From: [REDACTED]
Sent: 14 June 2018 16:08
To: Planning.Responses
Cc: Michael Eastham; Deborah Urquhart; Henry Moyo
Subject: A/67/18/DOC - Swanbourne Park, Angmering, Roundstone Lane - Highways response dated 14th June 2018 to planning application for discharge of conditions 8 and 10 (parking and road construction respectively)

TO:	Arun District Council FAO: Michael Eastham
FROM:	Tim Townsend - Highways, WSCC
DATE:	14 th June 2018
LOCATION:	Swanbourne Park, Land East of, Roundstone Lane, Angmering, BN16 4AL
SUBJECT:	A/67/18/DOC Application for approval of details reserved by conditions imposed on planning reference A/82/12 relating to condition no. 8 (car parking) & 10 (roads, footway & casual parking areas).
DATE OF SITE VISIT:	30 th May 2018
RECOMMENDATION:	☒ Advice ☐ Objection ☐ Modification ☒ No Objection ☐ More Information ☐ Refusal
S106 CONTRIBUTION TOTAL:	£N/A (secured at outline stage)

This is the second WSCC highways and transport response to the above application for approval of details reserved by conditions imposed on planning reference A/82/12 relating to condition no. 8 (car parking) & 10 (roads, footway & casual parking areas).

Drawing Ref
ST-02-12 T

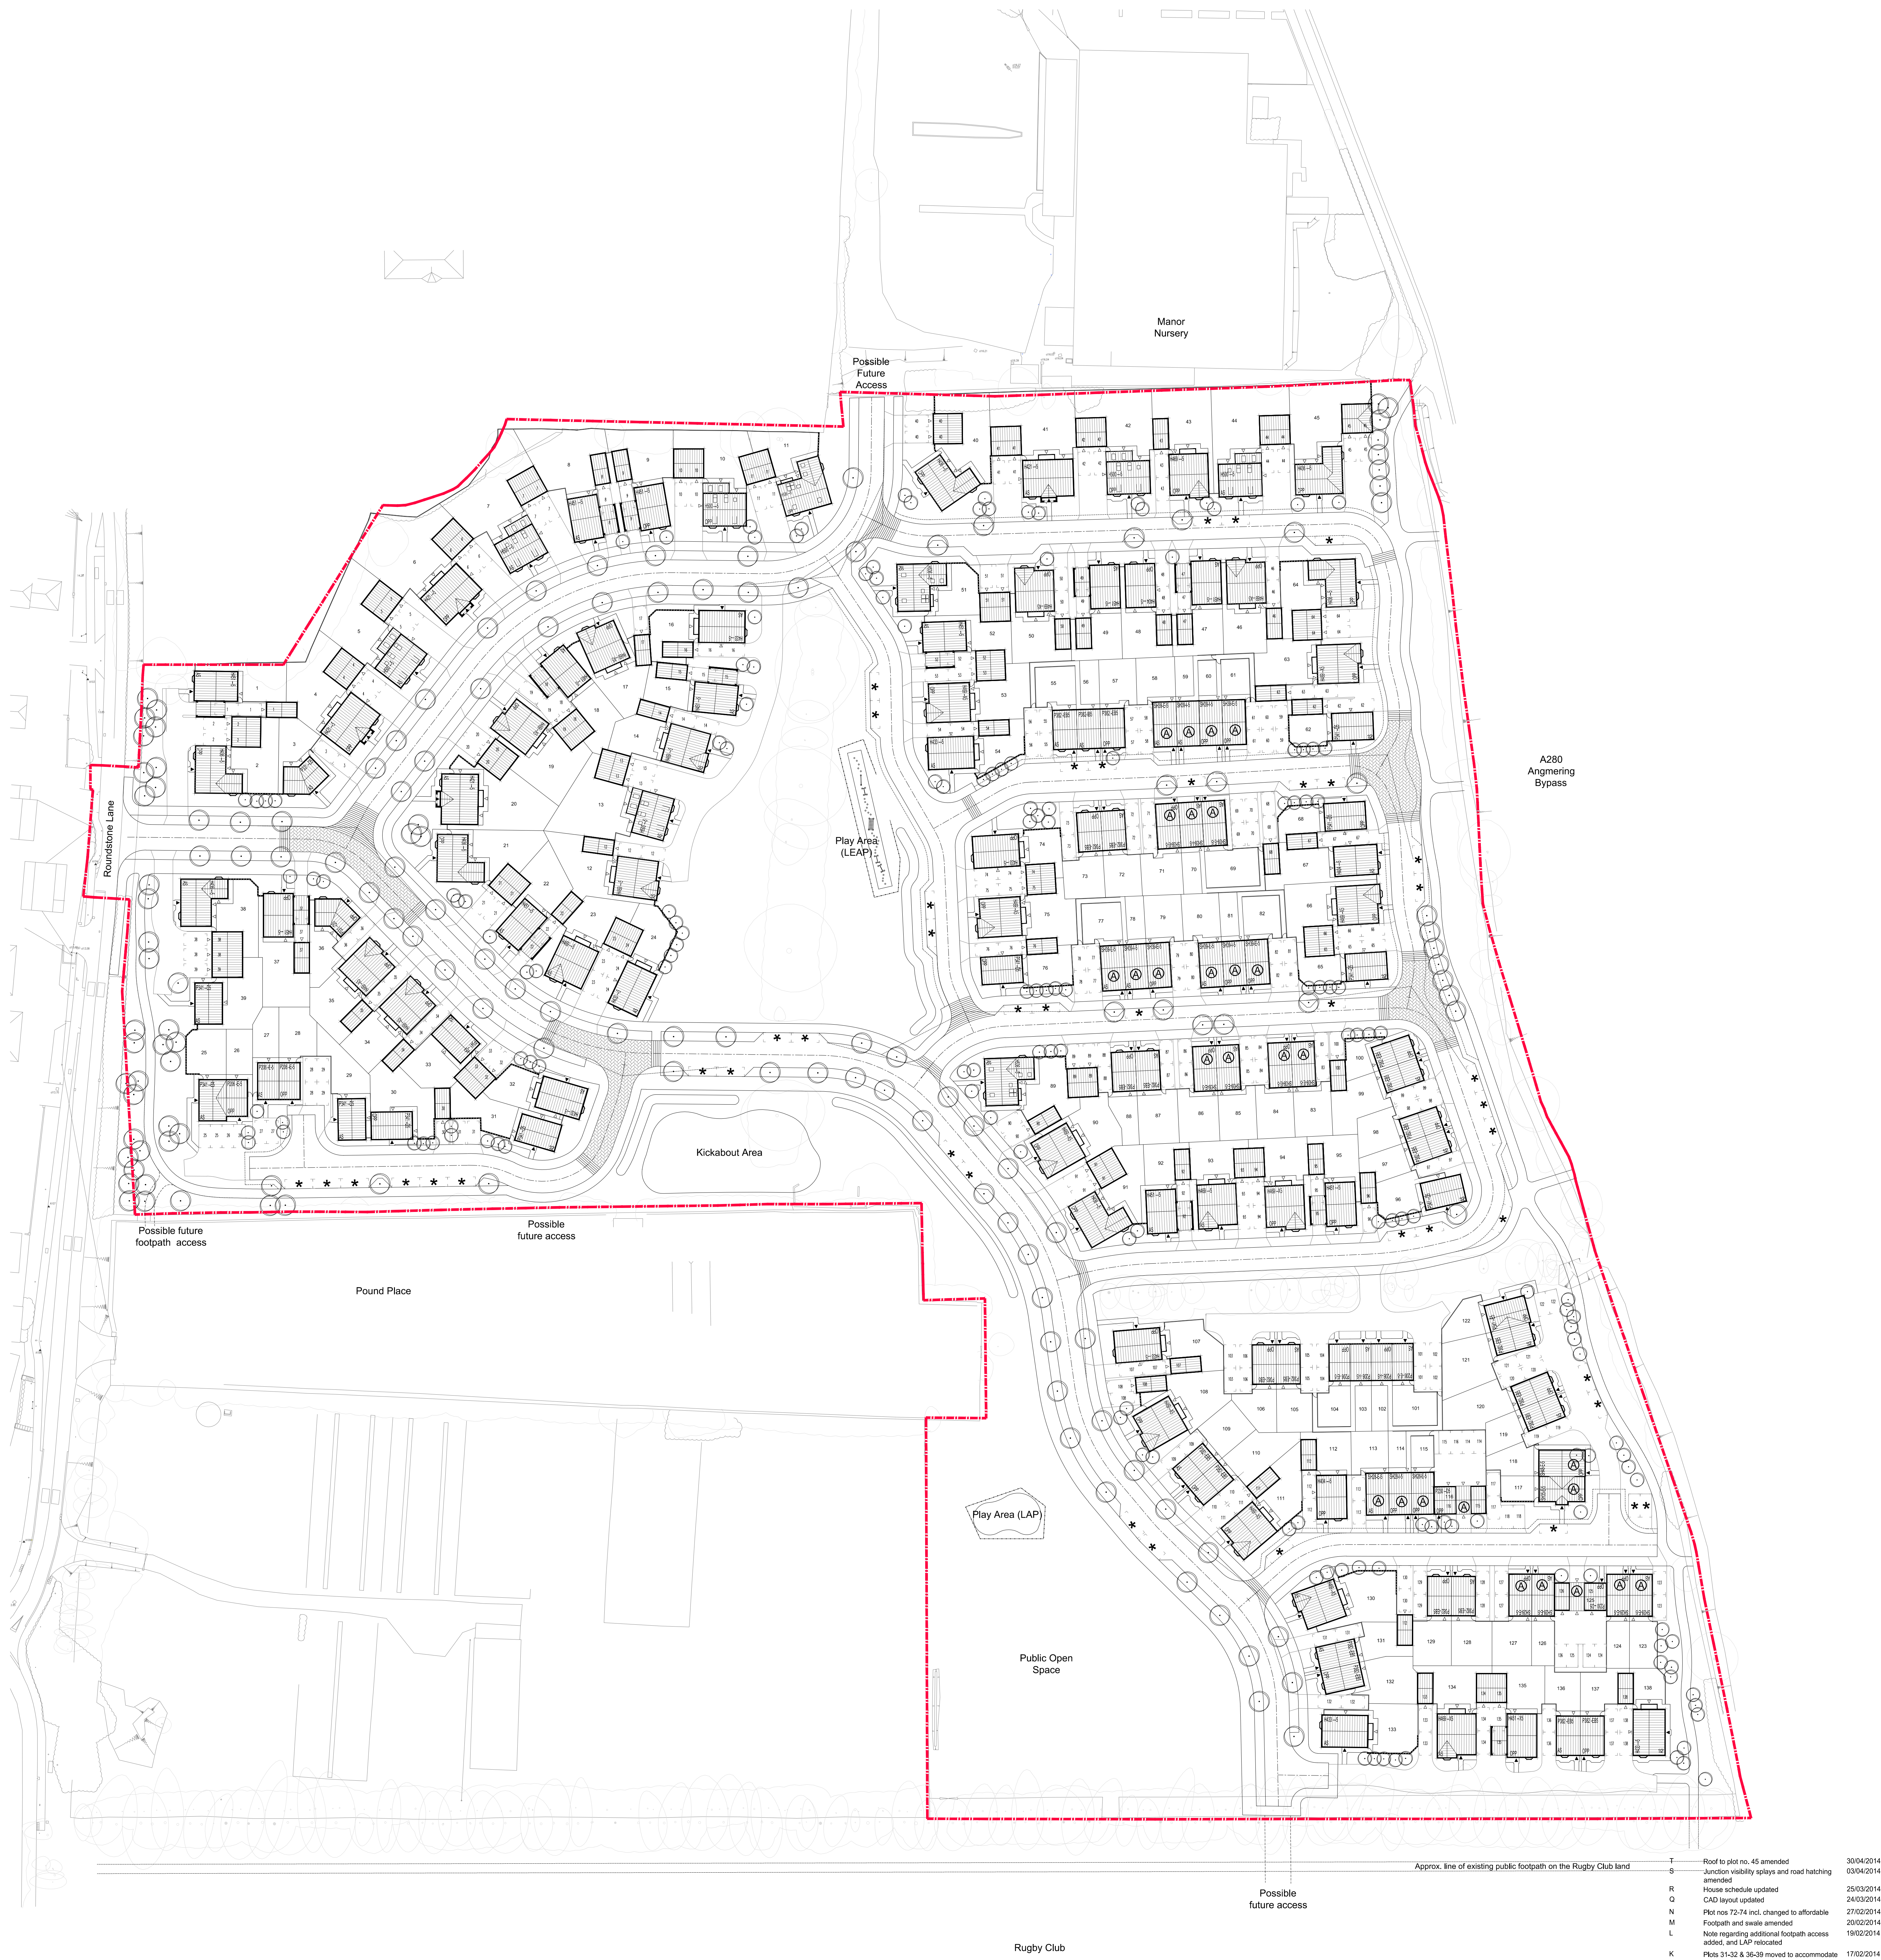
- 1. Condition 8 (car parking)** – Car parking appears to accord with the approved planning layout as shown on Drawing No. ST-02-12 T (dated 10th February 2014).
No highway objection.
